From: Martin Hill <Martin.Hill@arun.gov.uk>
Sent: 16 March 2020 10:48
To: Planning.Responses <Planning.Responses@arun.gov.uk>
Subject: RE: Planning Consultation on: BR/41/20/PL

Dear Planning, please find below comments from Private Sector Housing:

APPLICATION NO: BR/41/20/PL

Description of Works: Change of use from C3 Dwellinghouses to a House in Multiple Occupation (Sui generis) including internal & minor external alterations.

PROPOSED FIRST FLOOR PLAN
1:50

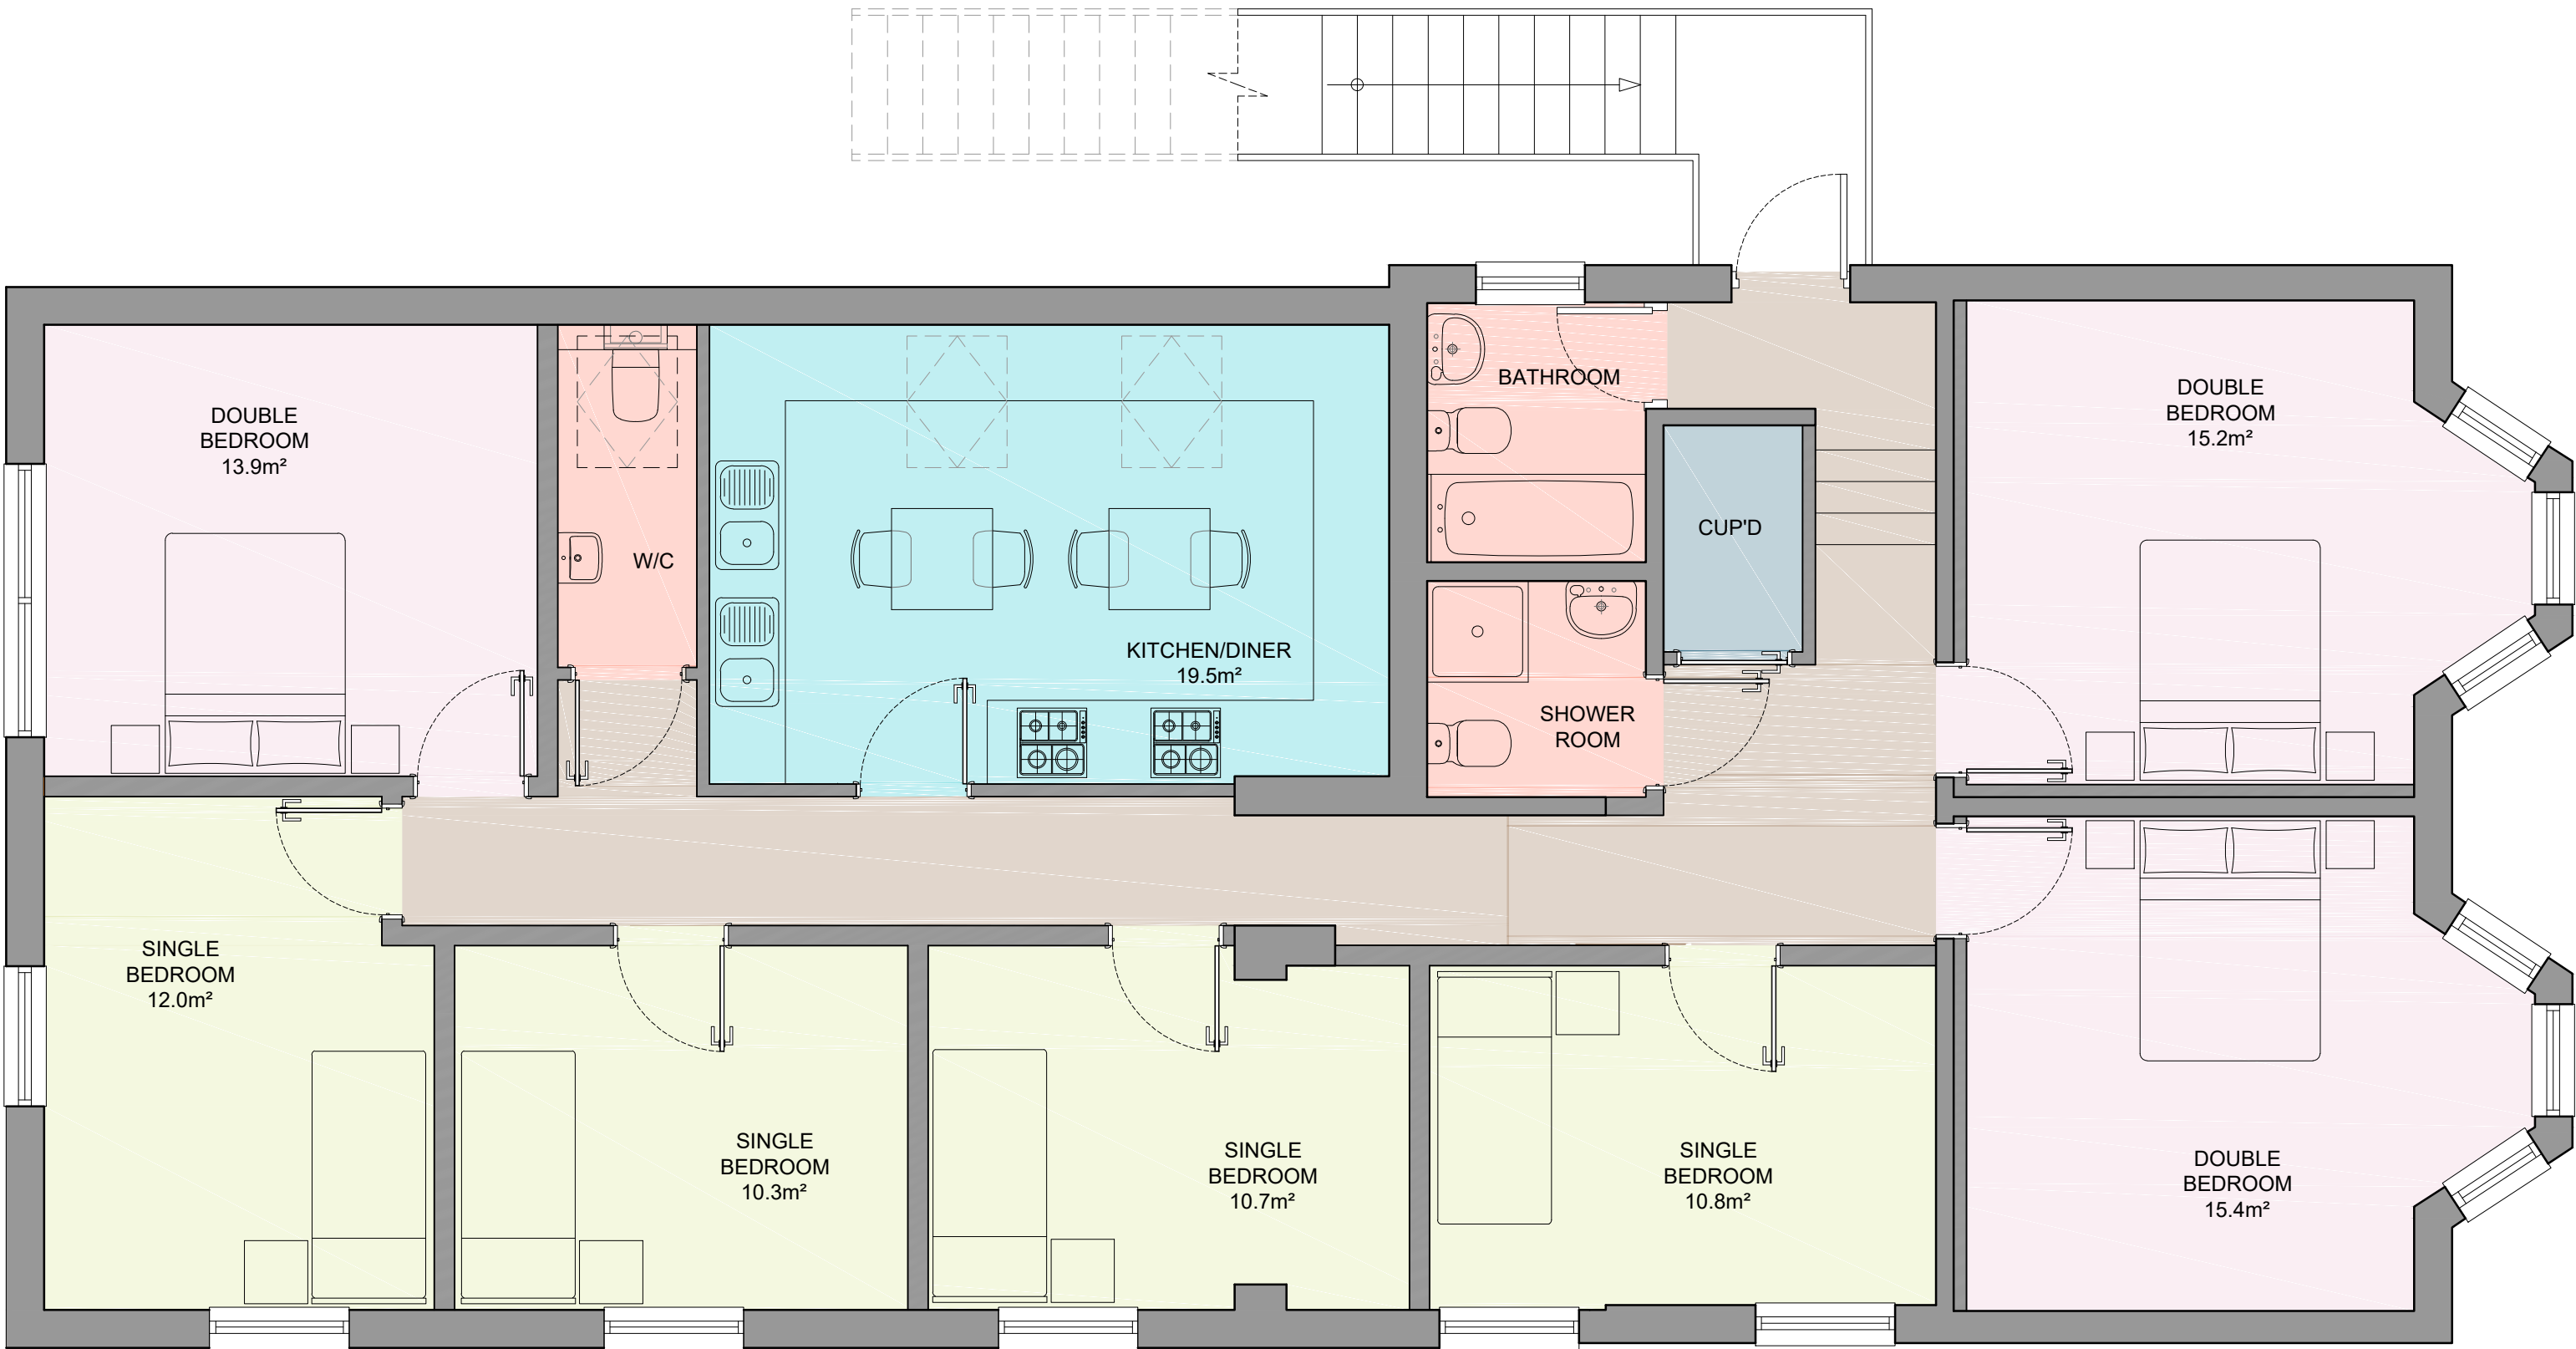
- The external staircase serving the first floor is their sole means of escape, therefore it should be protected from the effects of fire along its length. The sensitive area is 1.8m horizontally therefore any windows in this region should be fire resisting construction and if possible fixed shut and any doors should be fire resisting and self-closing.

PROPOSED GROUND FLOOR PLAN
1:50

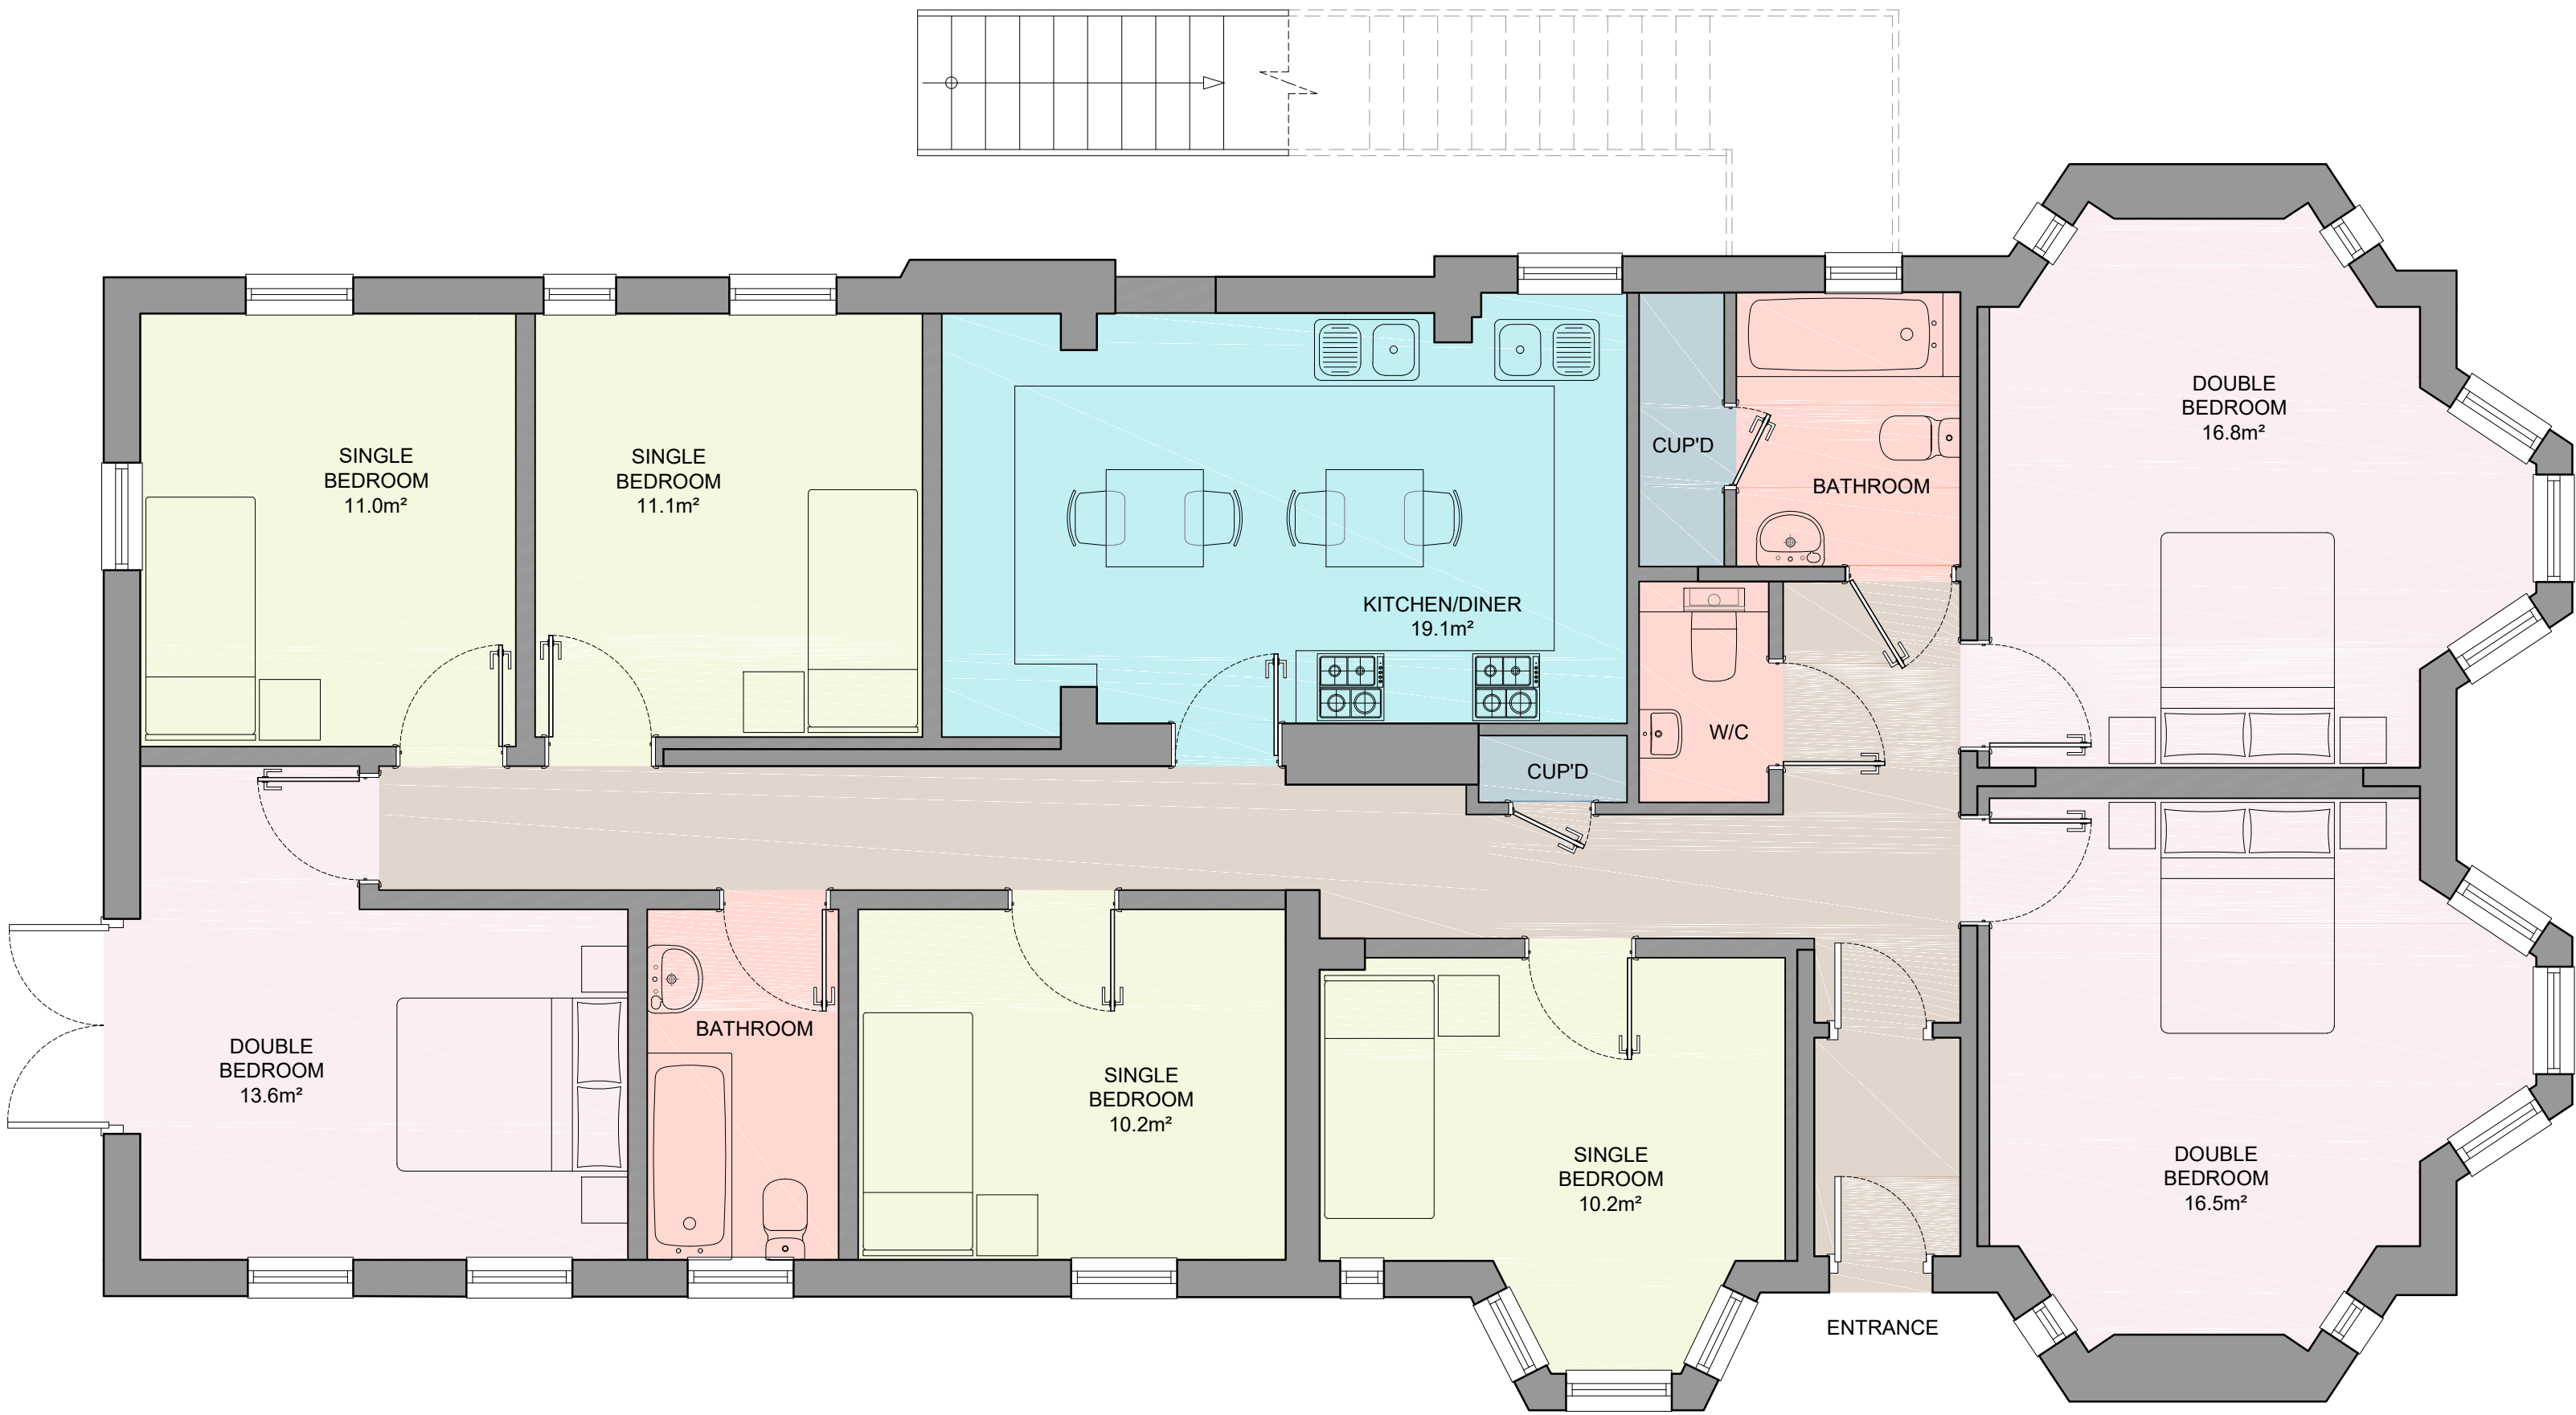
- 30min fire resisting escape route, which would include providing a 30 minute fire resisting and self-closing fire door to the kitchen, bedsits, cupboards and any other identified risk areas opening on to the escape route.
